**ADC Planning Consultation
Response from the Historic Buildings Adviser**

Application Number	LY/12/14/L
Address	Travis Perkins, The Causeway, Station Yard, Arundel, BN18 9JL
Description	Application for Listed Building Consent for repairs & alterations to roof.
Case Officer	Anita Gardner
Site Visit

Drawing Title: Plans and Elevations

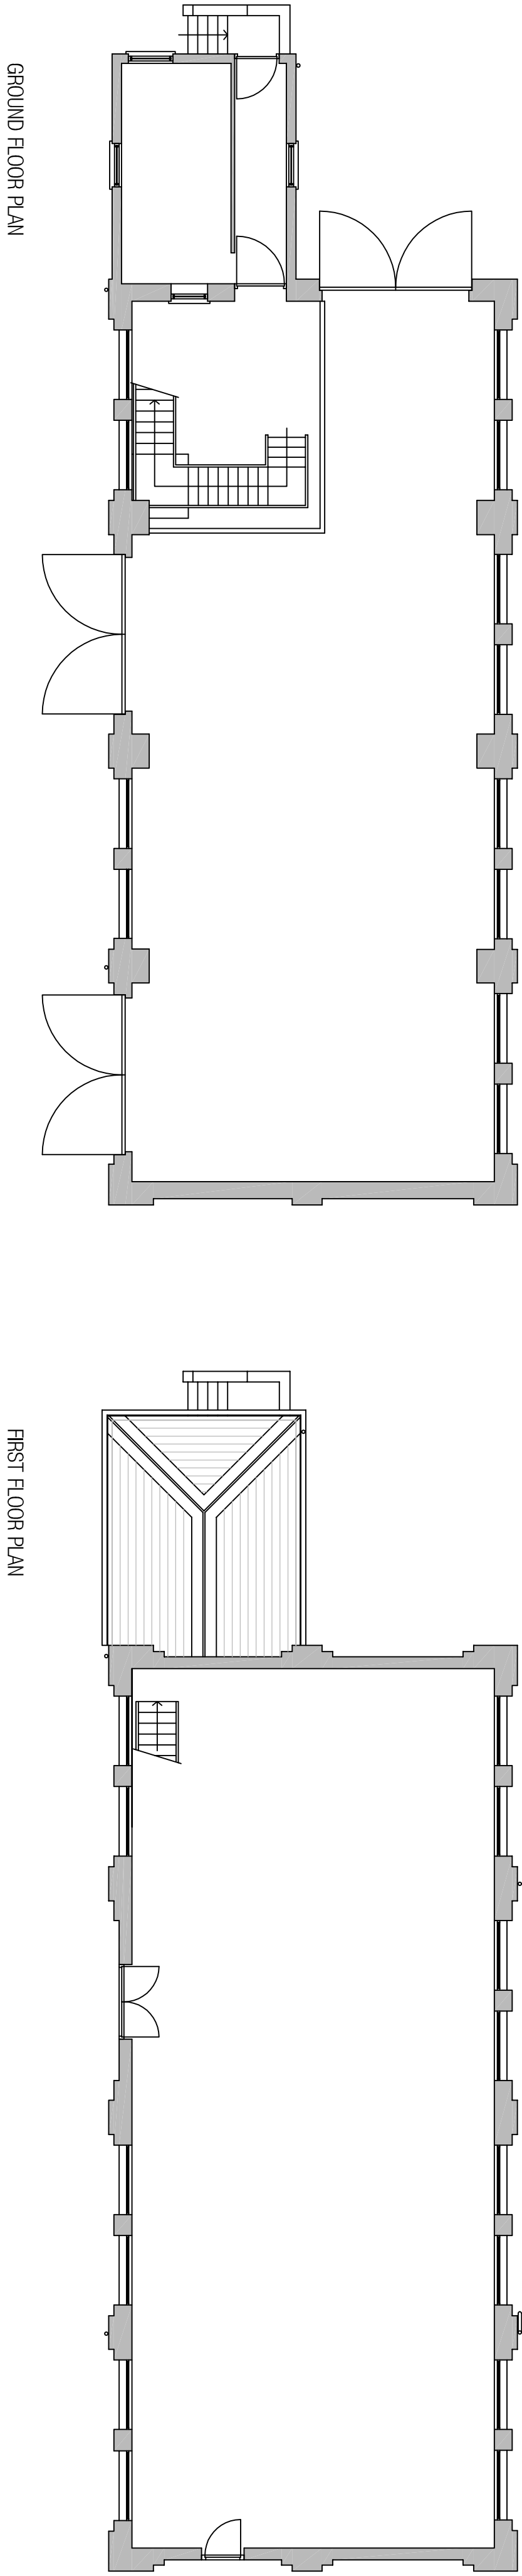
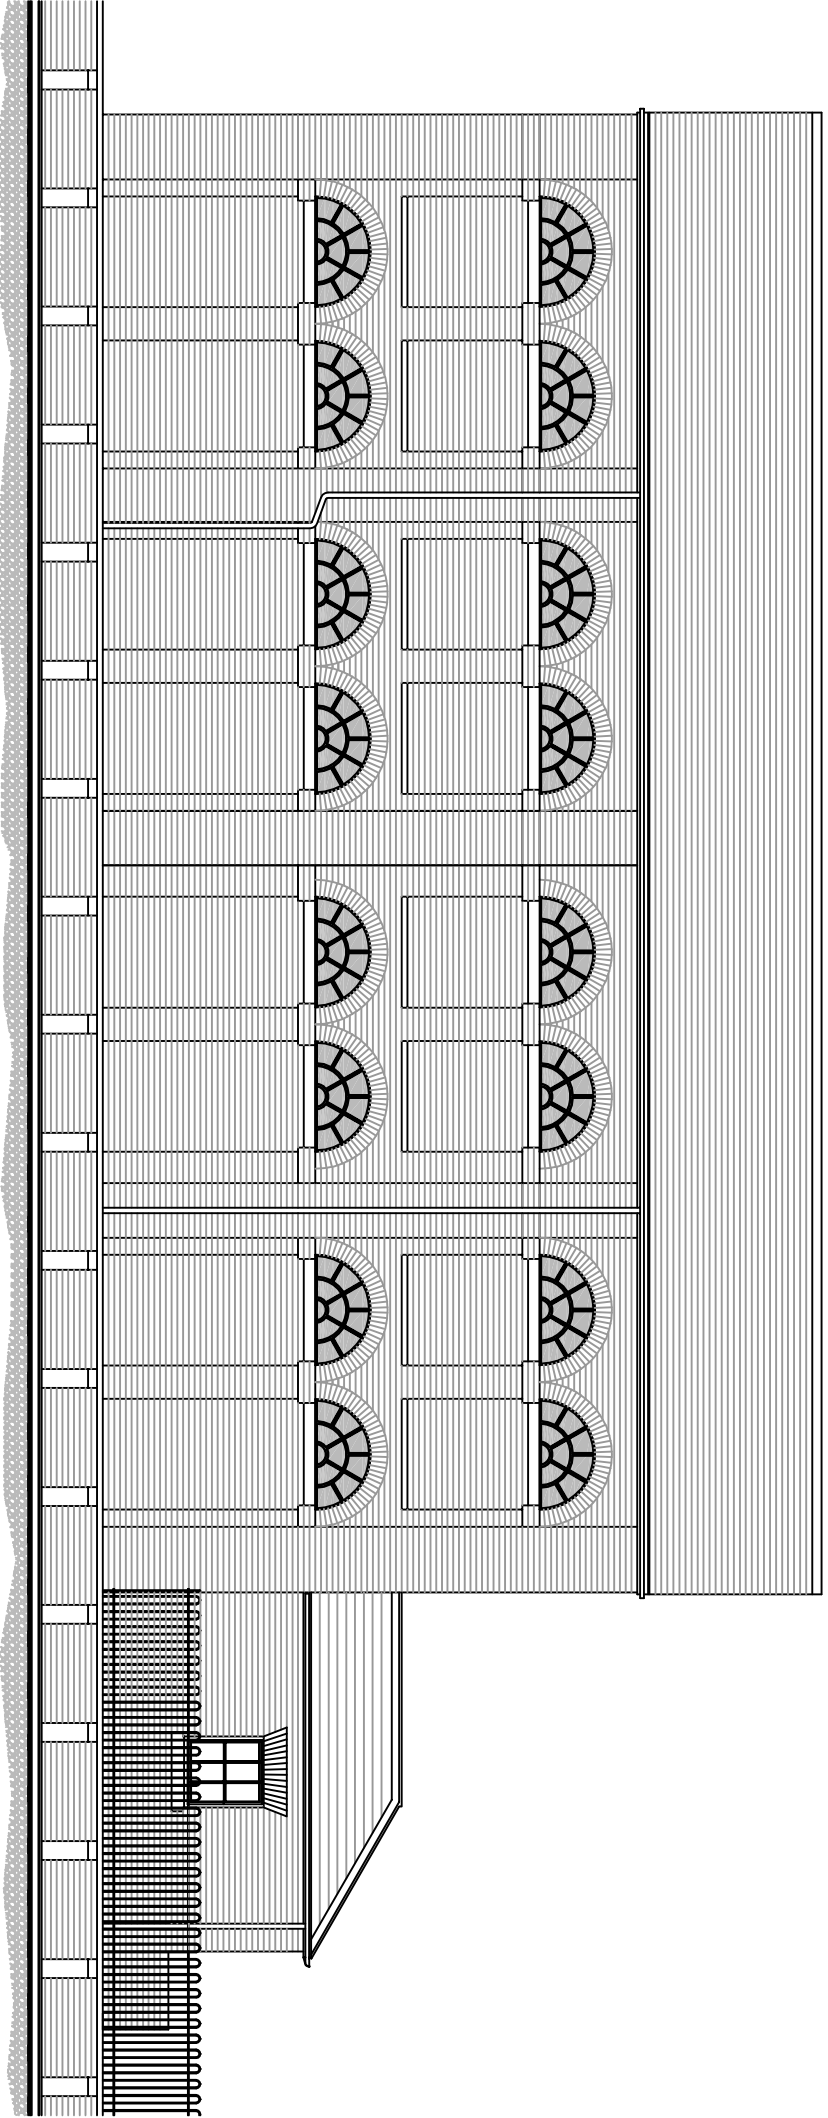
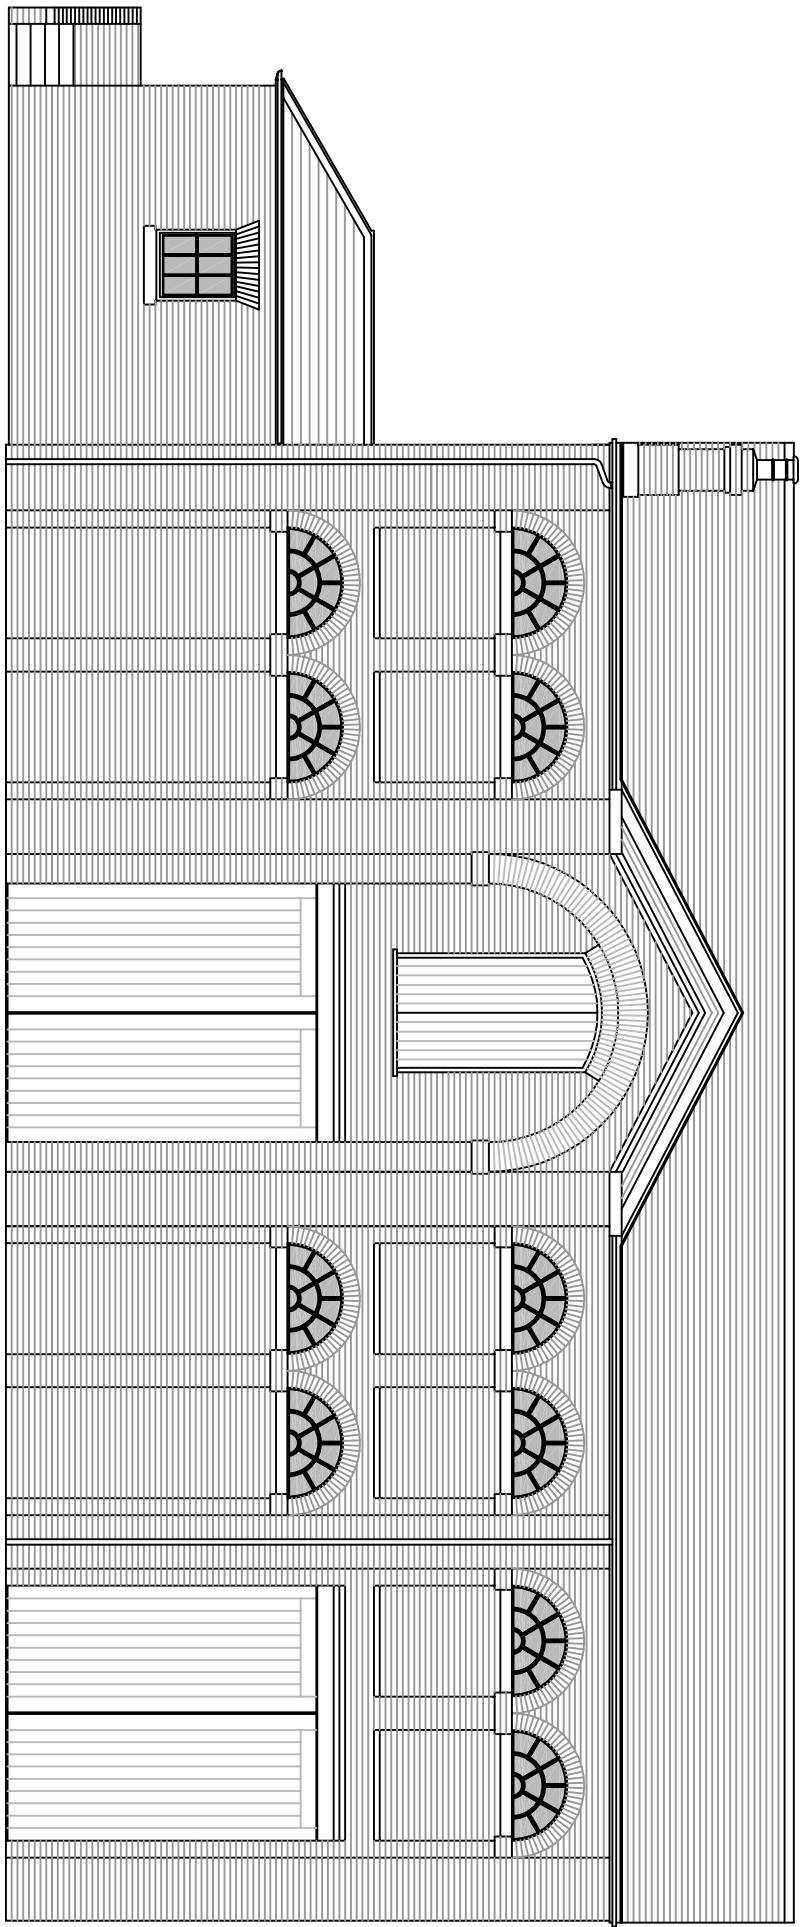
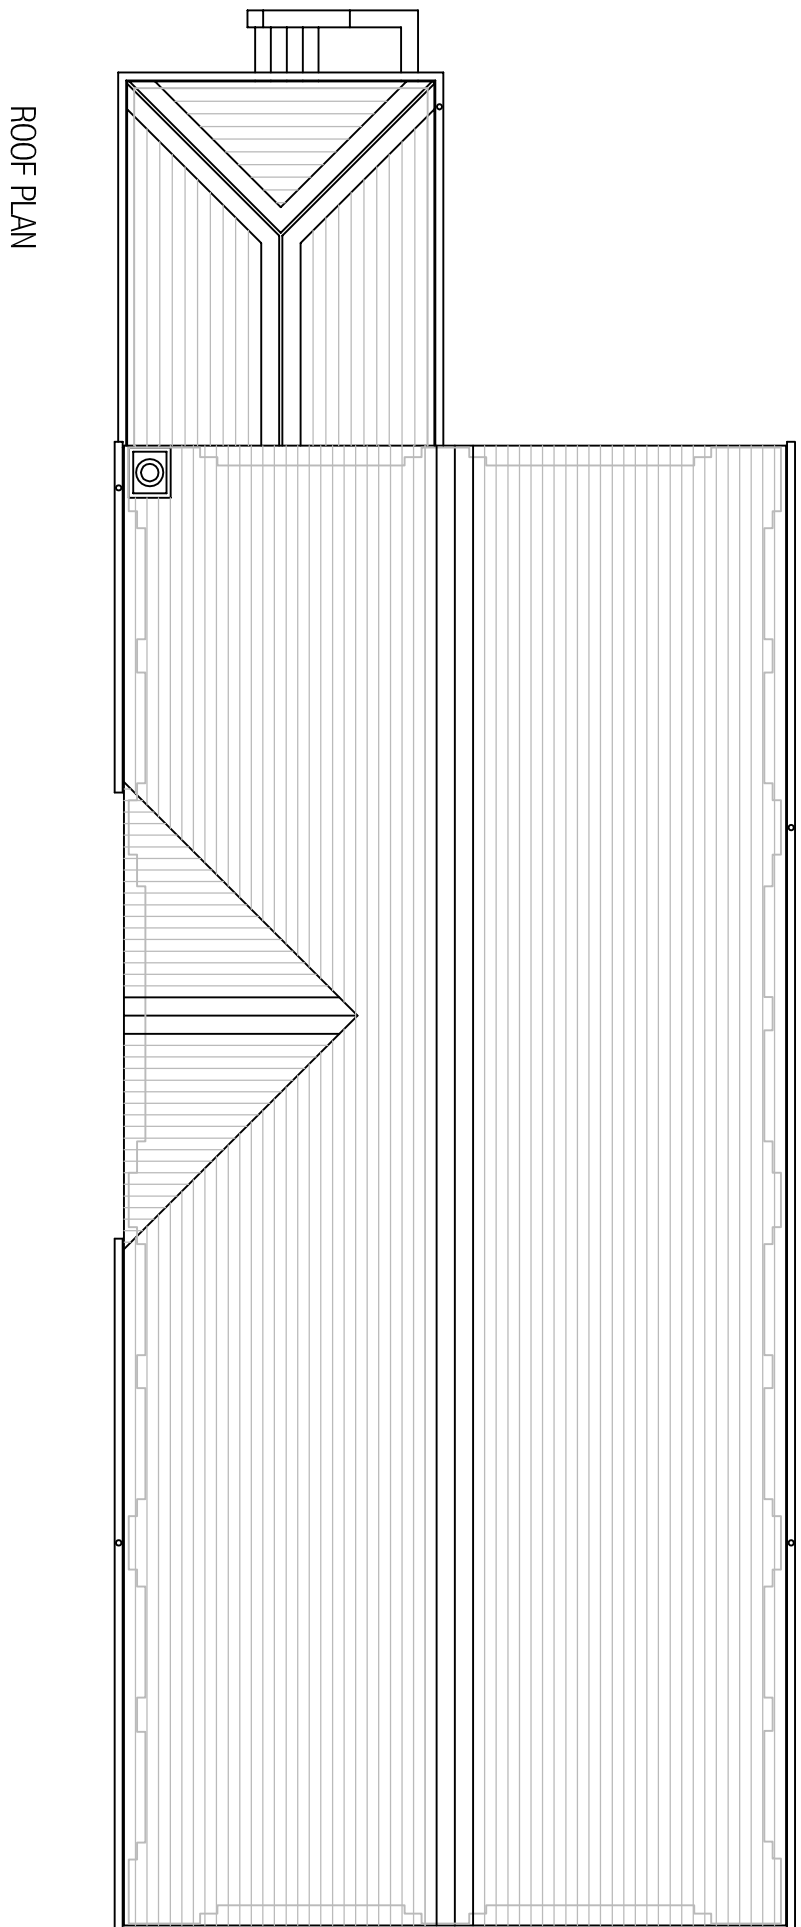
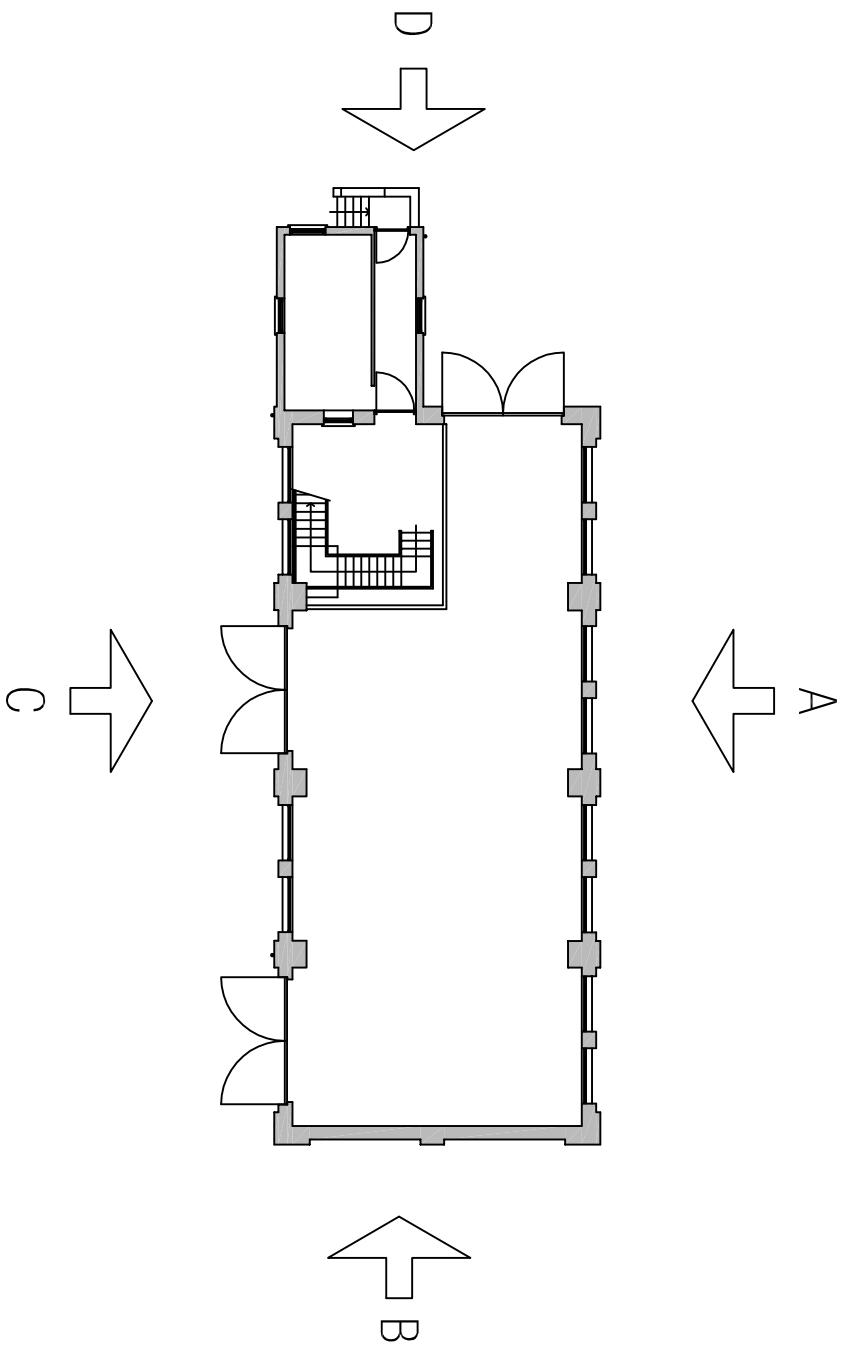
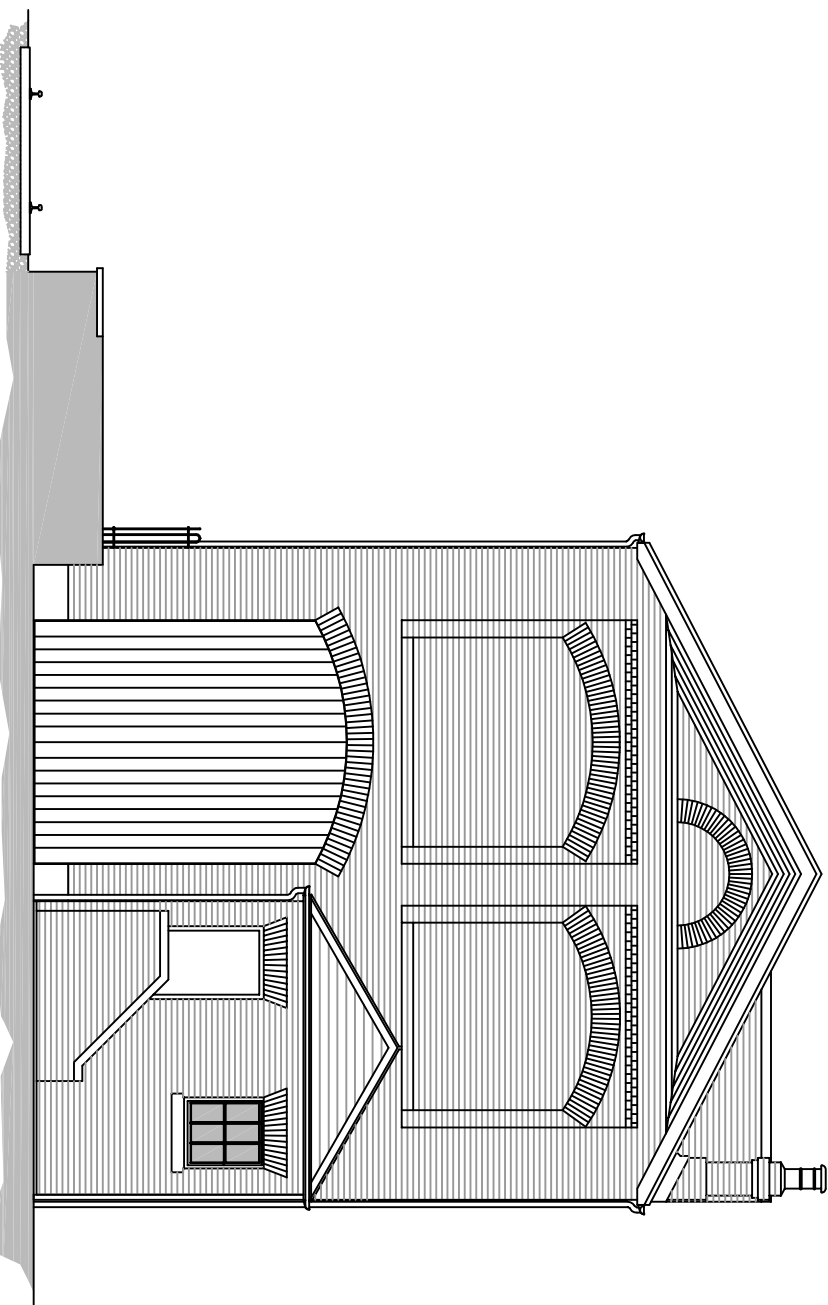
- repairs to the rubbed brick arches – method statement by appropriate contractor
- details of timbers affected and qualification for their removal – repair required if feasible. This includes barge boards and fascia.
- details of which metal windows are beyond repair and qualification for replacement
